**THE HILLS SHIRE COUNCIL**

29 August 2017

**Bella Vista Primary School – Development Application**

PROPOSED SITE PLAN

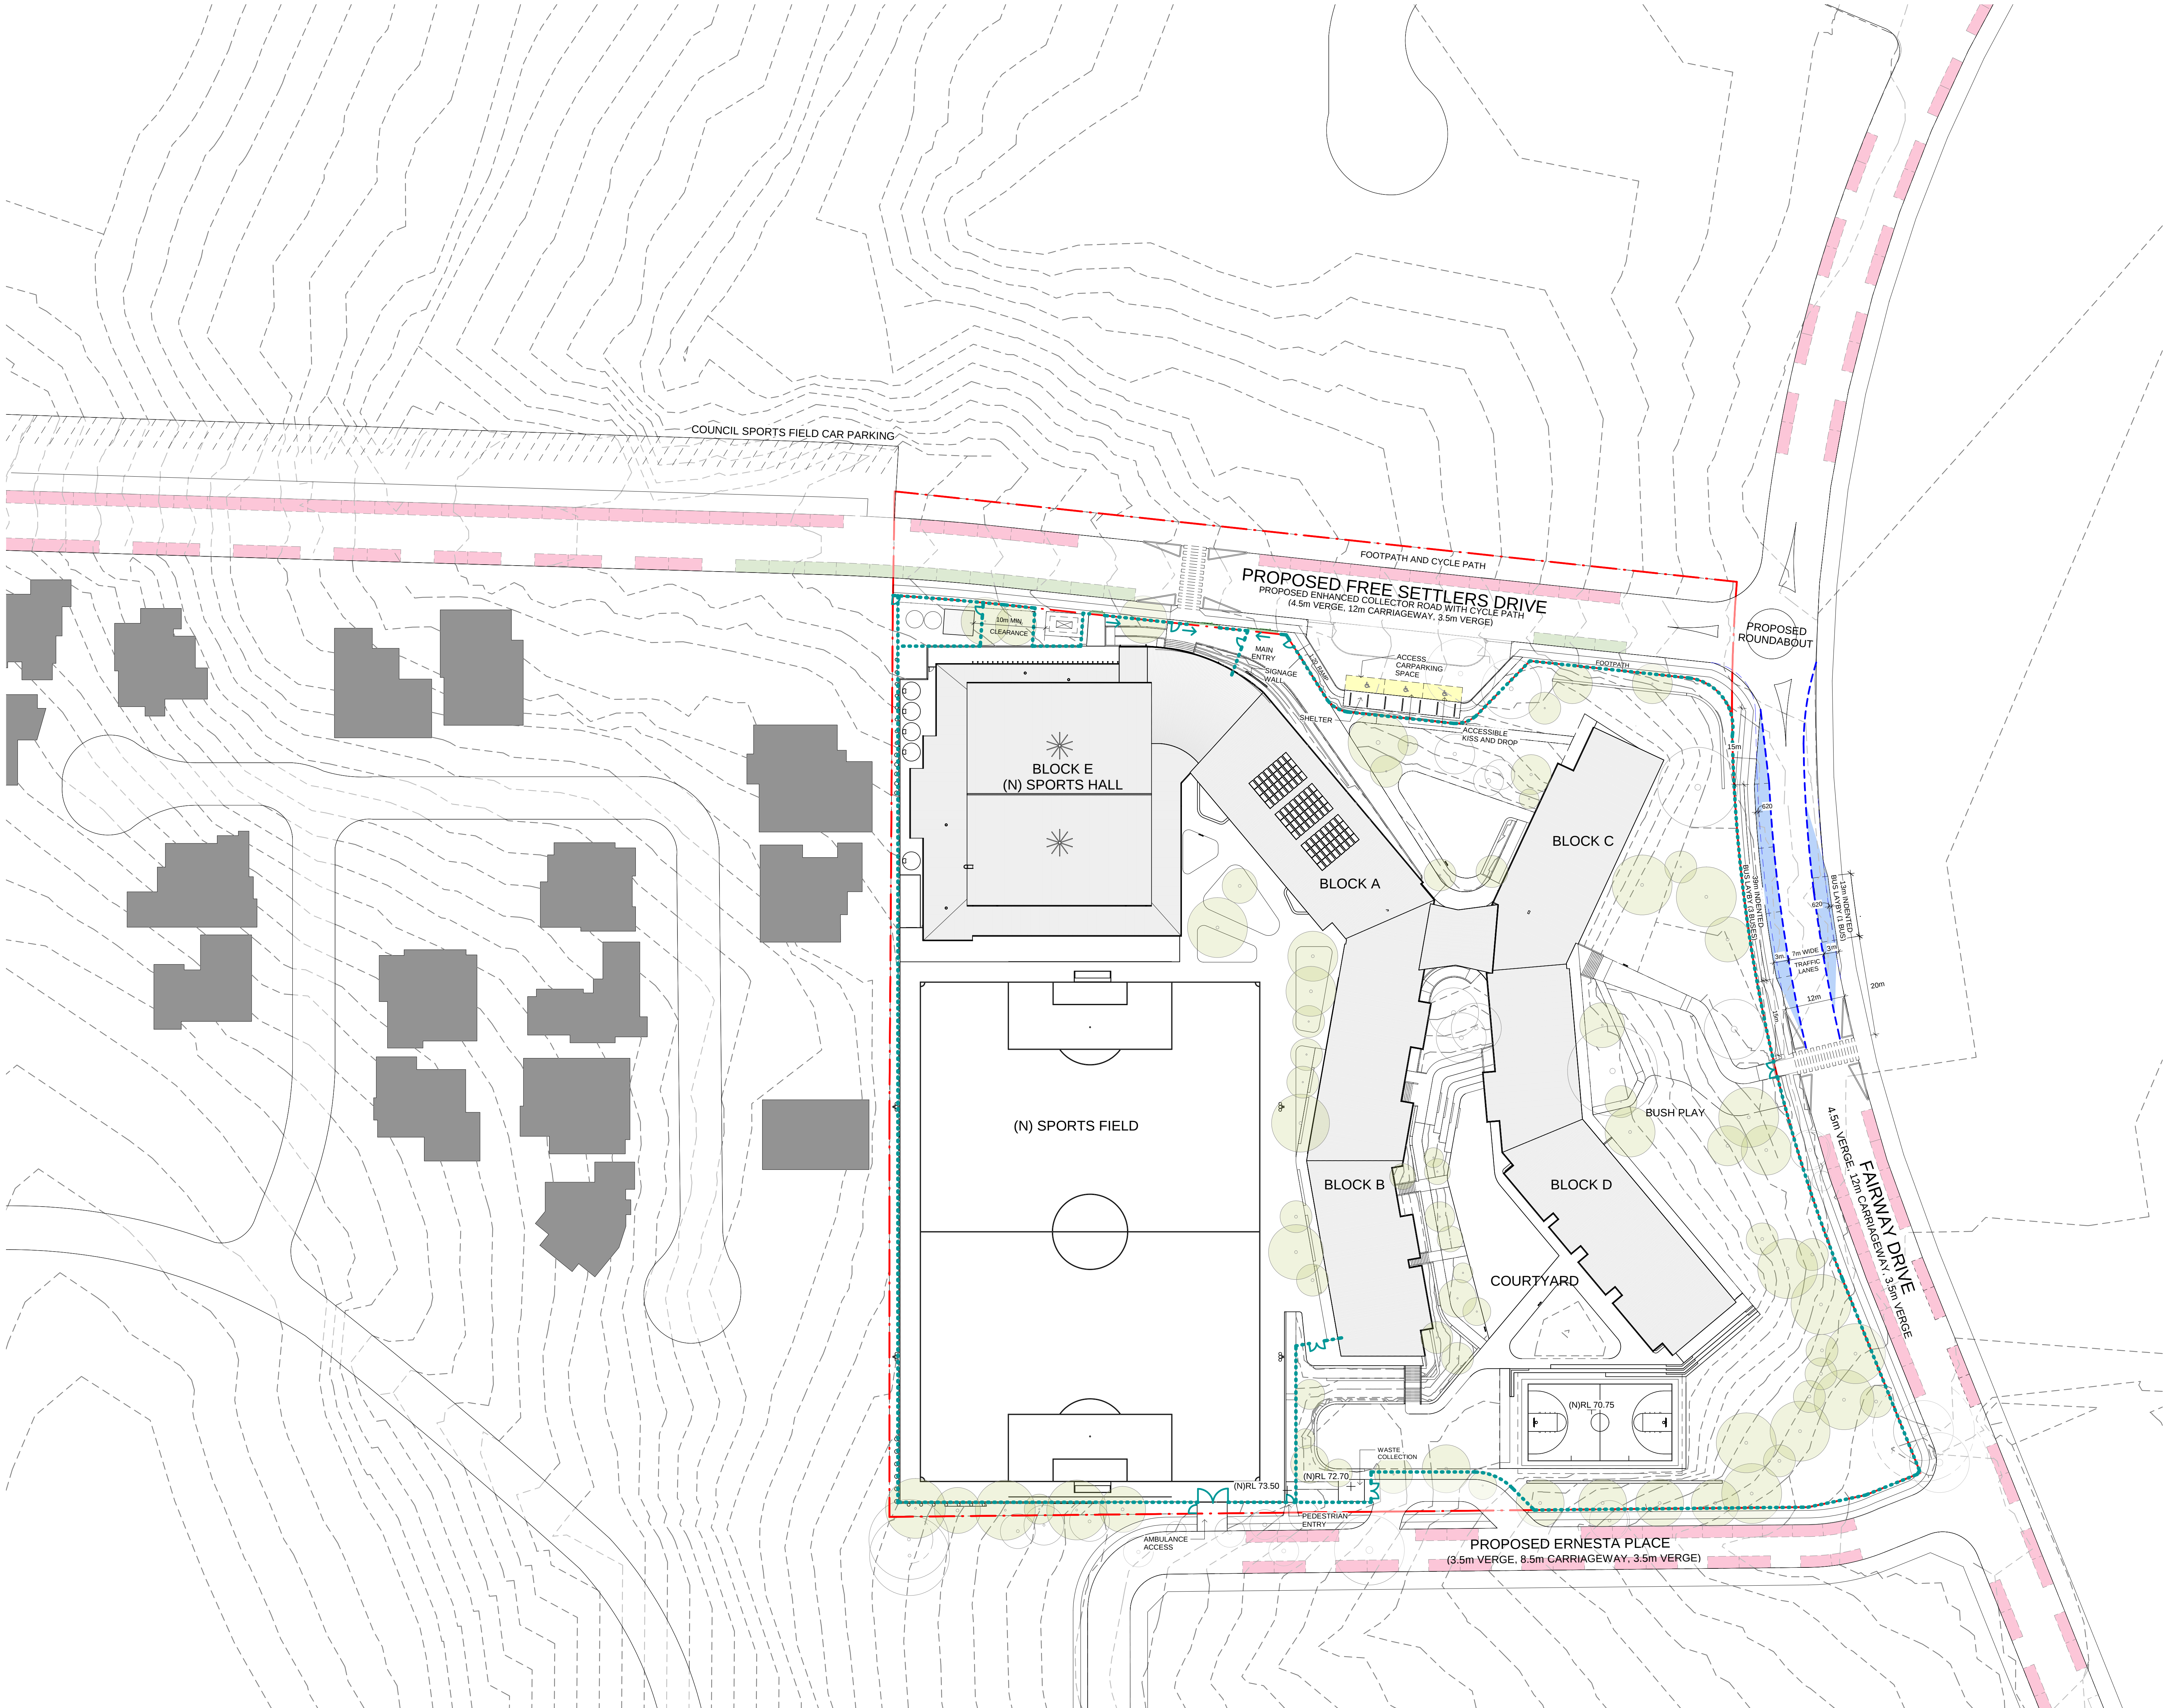
2. *"Kiss and Drop" Zone Design*

**Council Comment**

The project incorporates a "kiss and drop" zone off Free Settlers Drive that will accommodate safe drop off and pick up of special needs students. The concern raised by Council was that this would create a conflict between many other students being dropped off by parents on Free Settlers Drive, and the vehicles entering and exiting the accessible drop off and pick up point. The road design being done by Council will alter the parking restrictions along this section of Free Settlers Drive adjacent to the accessible drop off, into a short "NO STOPPING" zone and relocating the "kiss and drop" further west up Free Settlers Drive. This would effectively extend the proposed "kiss and drop" to accommodate more parent parking away from the area designated for special needs access.
